DOC19/487894-12

**Request for comment on proposed Data Centre, Roberts Road, Prospect, NSW (SSD-10330)**

I refer to the Department of Planning, Industry and Environment's email on the 3 December 2019 requesting the NSW Environment Protection Authority's (EPA) comments on an Environmental Impact Statement (EIS) for the Roberts Road Data Centre (SSD-10330).

Figure 6 : HV Generator locations (shown in red)

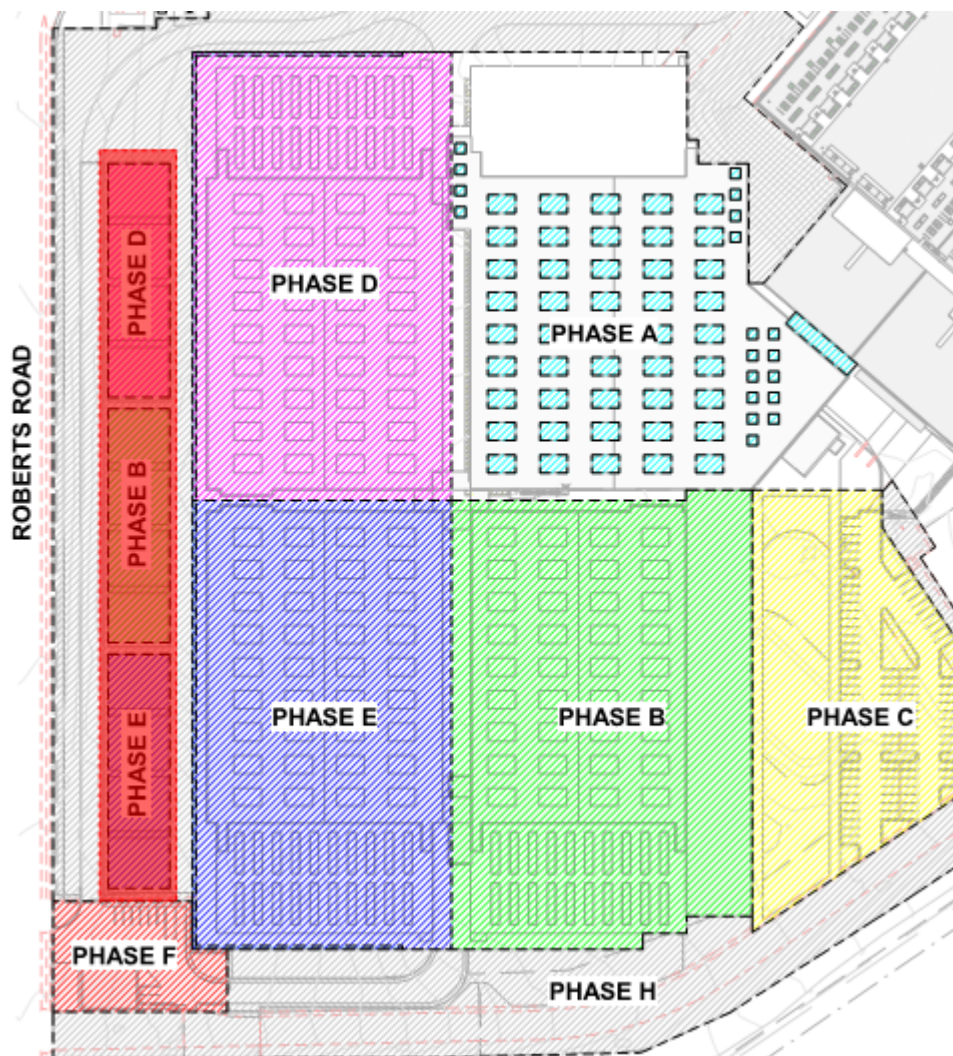
The EPA requests further information about the emergency power generators including:

- a. individual capacity (in terms of megawatts and megajoules per second);
- b. testing procedure, frequency and duration;
- c. confirmation that testing will be carried out individually or in clusters;
- d. justification of the need to test during the evening or at night; and
- e. maximum operating time in an emergency situation.

The EIS does not provide details on what the testing involves. Assuming that 'testing' requires the generators to operate at their full capacity, then there is potential for noise and air pollution impacts to go beyond what is intended to be captured by the exemption in clause 17(1A) of Schedule 1 of the POEO Act. Therefore, it is EPA's opinion that the proposed activity, based on the information provided, may require an environmental protection licence for electricity generation.
